PLAN REVIEW SHEET

Date: October 22, 2020

Petition #: RZP 2020-134

Staff Contact: John Howard

**RZ-1.0**

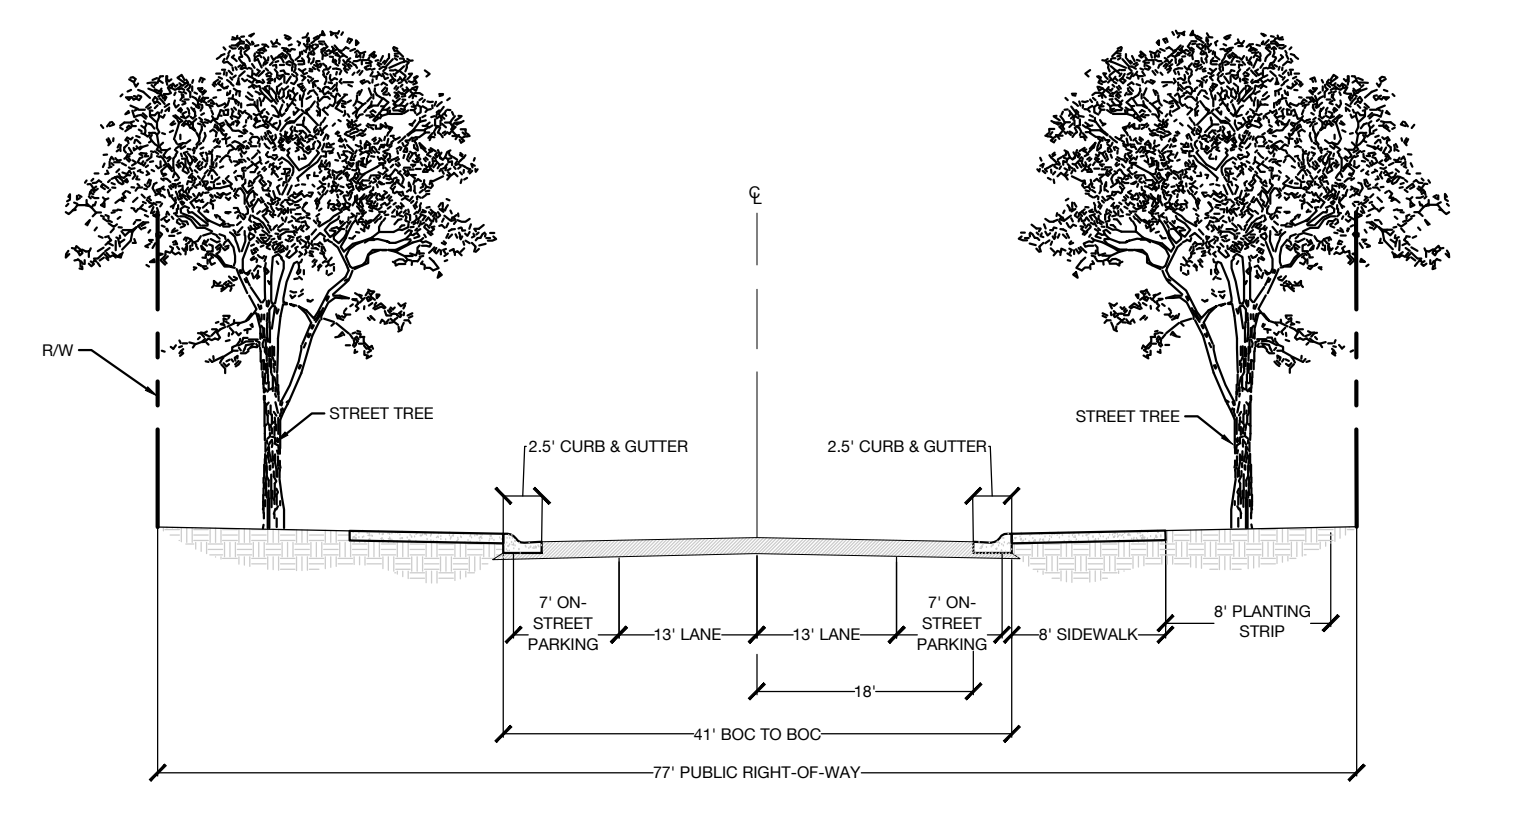
The site is located along CATS local bus route #18 along Mount Holly Road. CATS requests the petitioner to construct an ADA compliant bus waiting pad per Land Development Standard 60.01B at the location of the existing stop (ID #46533). The final location of the pad will be coordinated with the developer through the permitting process.
